City of Albuquerque Stormwater Construction Site Inspection Report

Project Name and Location	Sunset West Unit III Sage & Sunset		
Site Contact Name & Agency	Jose Lopez	ESC File No. NPDES ID No.	LD950121
Date of Inspection	12-10-18	Start/End Time	11:30 / 11:35
COA Inspector Name	Curtis Cherne, Stormwater Quality		
Describe Present Phase of Construction	stabilizer

**Re: Drainage Control Ordinance Violations; 8700 Sunbow Ave SW and 920
Suneast Dr SW 4875 Pan American Frwy NE**

Re: Drainage Control Ordinance Violation

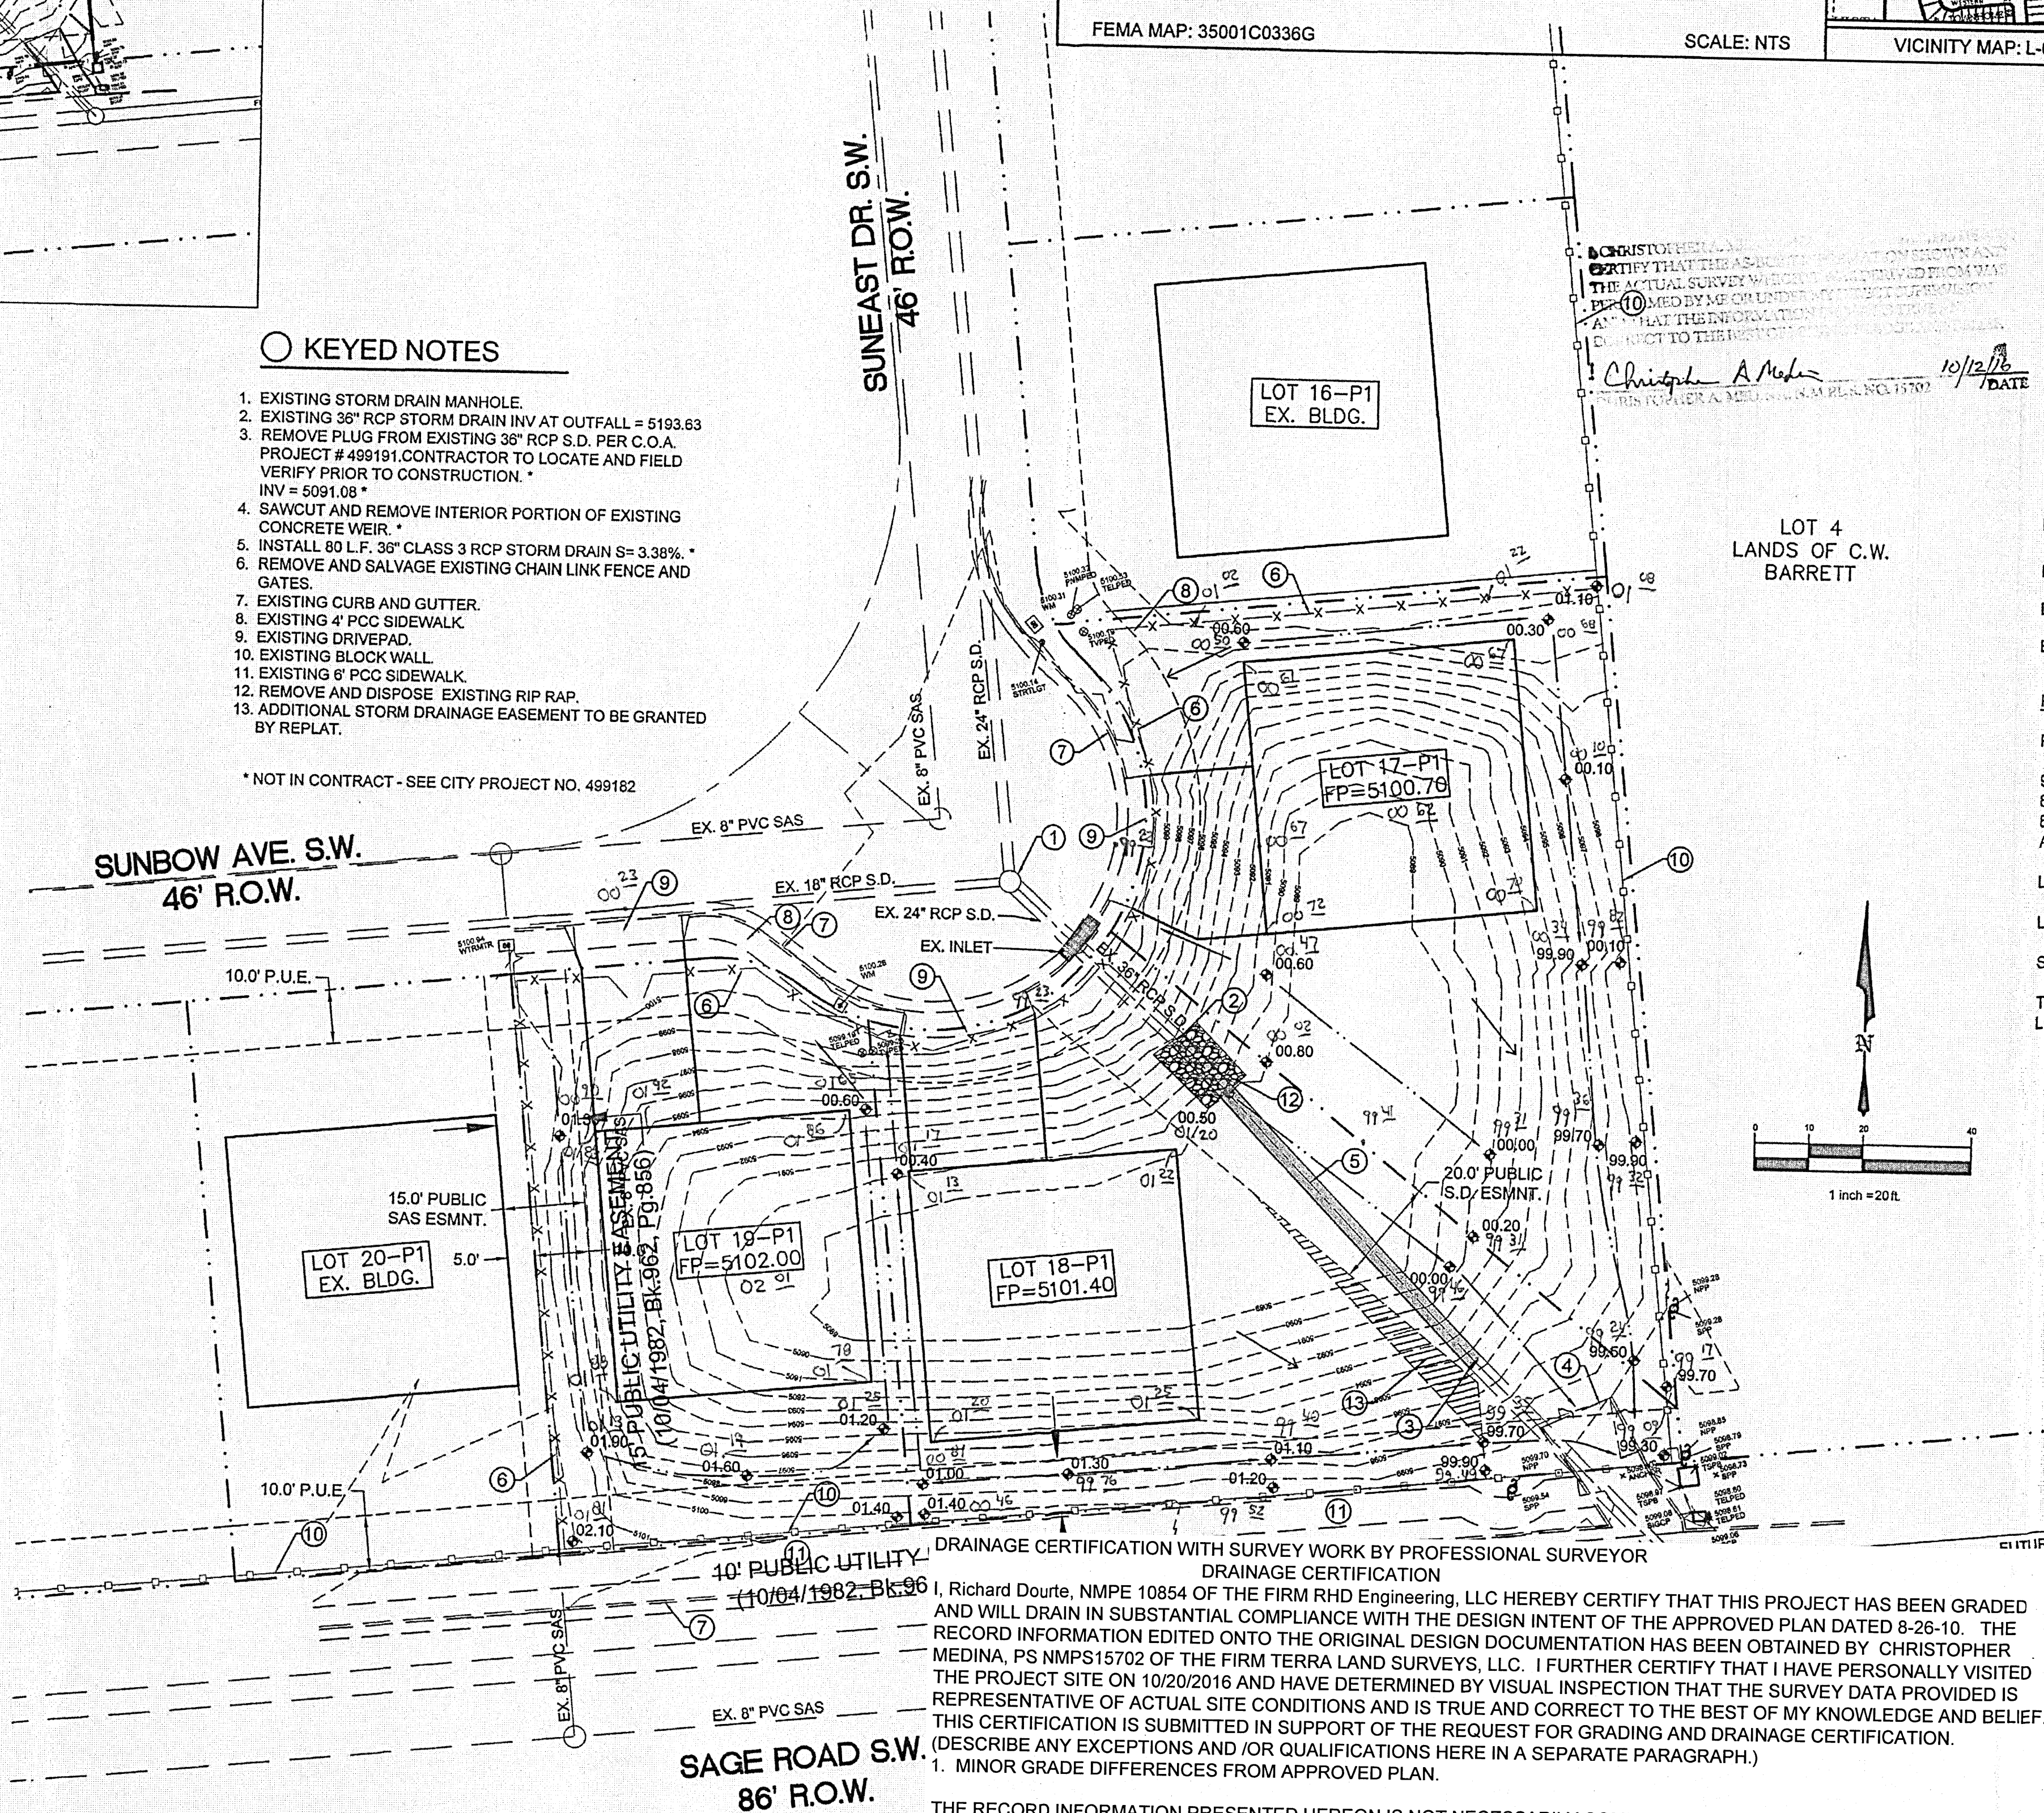
I discuss this with the City Engineer (copied on e-mail) and he would like you to build a sedimentation pond just north of the drainage holes in the wall. Sedimentation ponds trap sediment from upstream and slow the velocity of the water so the water should be non-erosive when it overtops the pond.

I sized the pond based on the 10-year storm rainfall amount (0.44" excess) and the drainage basin as shown on the engineer's certification by Richard Dourte, dated 10-20-16.

I calculated a volume of 515 cubic feet, which would be a shallow pond 20 ft x 20 ft x 1.3 ft deep. I went with a shallower pond for ease of construction.

The approved drainage plan/pad cert (cert date October 2016) shows a basin to drain through the wall and over the sidewalk.

The lot with the drain holes is not currently under construction.

I was going to ask them to put a filter sock/sediment BMP in front of the holes in the wall, but since Hydrology approved the drainage plan for it to drain like this, it seems I should let it go until the lot with the drain holes is under construction.

Create depressur
to prevent sediment
from accumulating on the
sidewalk / getting into street
